CITY OF ALBUQUERQUE

November 24, 2025

**Re: Take 5 Car Wash
980 98th St SW
30-Day Temporary Certificate of Occupancy
Transportation Development Final Inspection
Engineer's Stamp dated 06-09-23 (M09-D035)
Certification dated 11-21-2025**

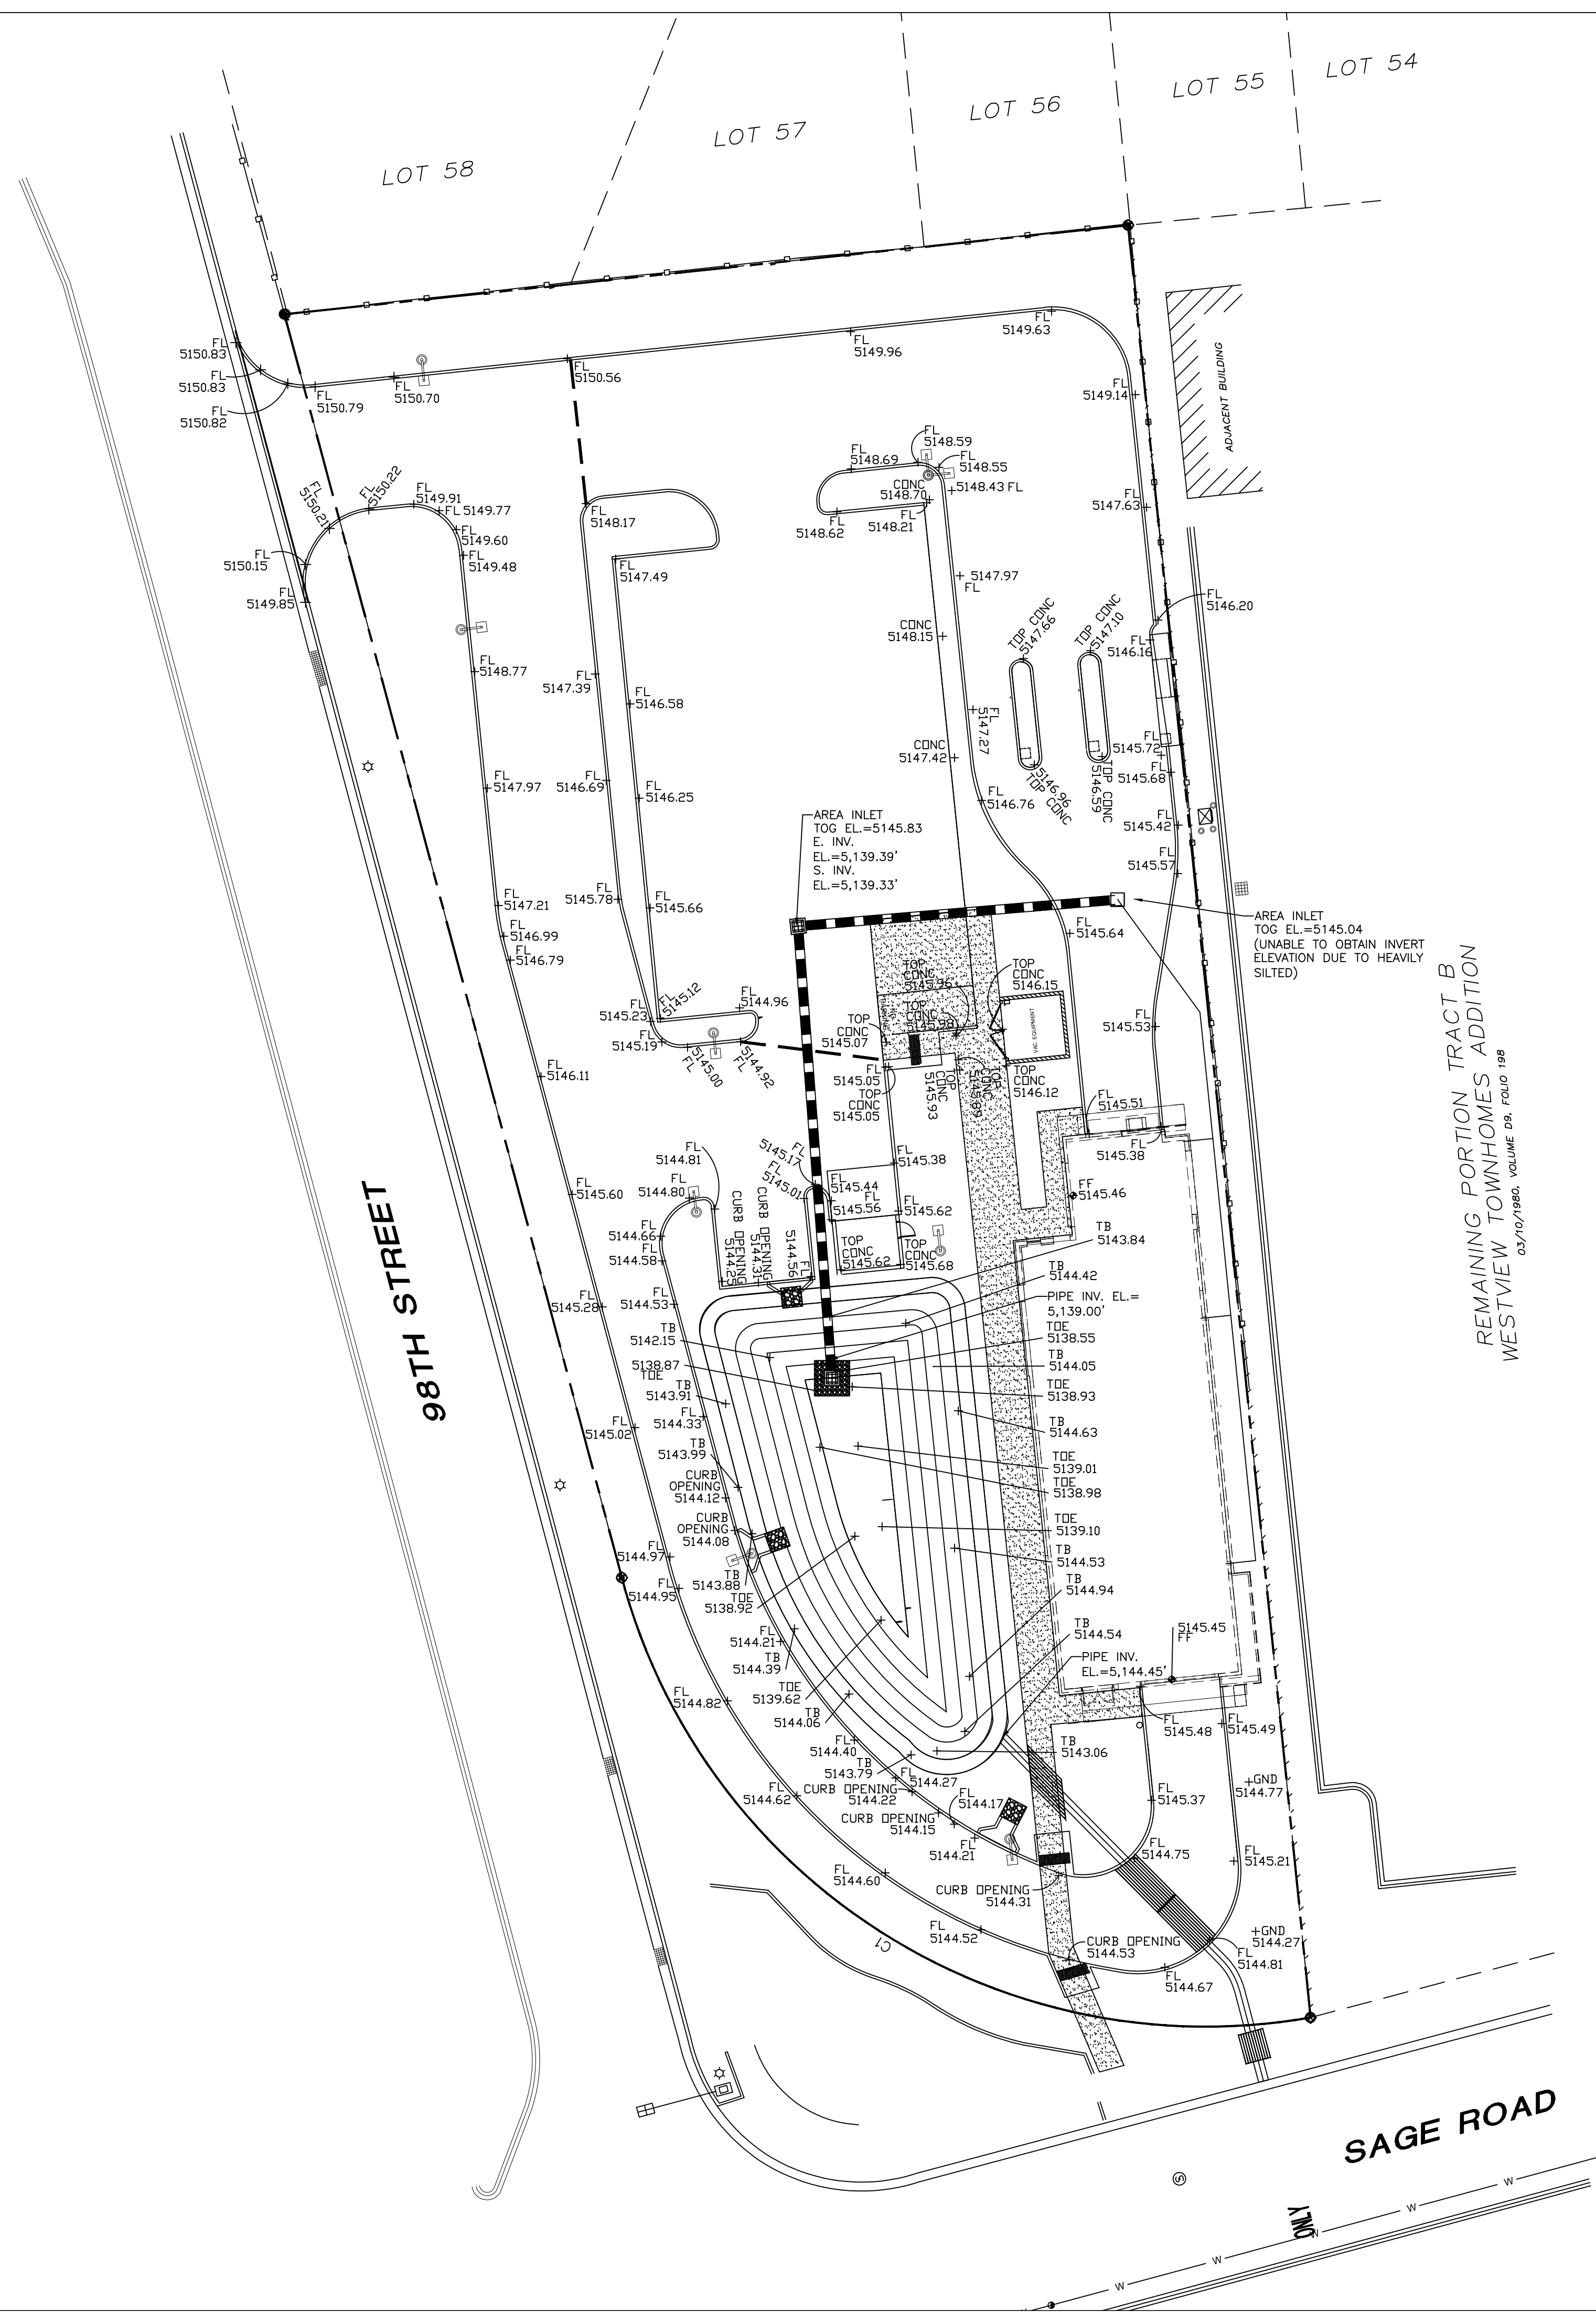
- The site access construction must be completed.
- Per approved site plan, please provide:
 1. ADA parking space signage.
 2. The "ONE WAY" and "DO NOT ENTER" signage.
 3. The Motorcycle parking space.
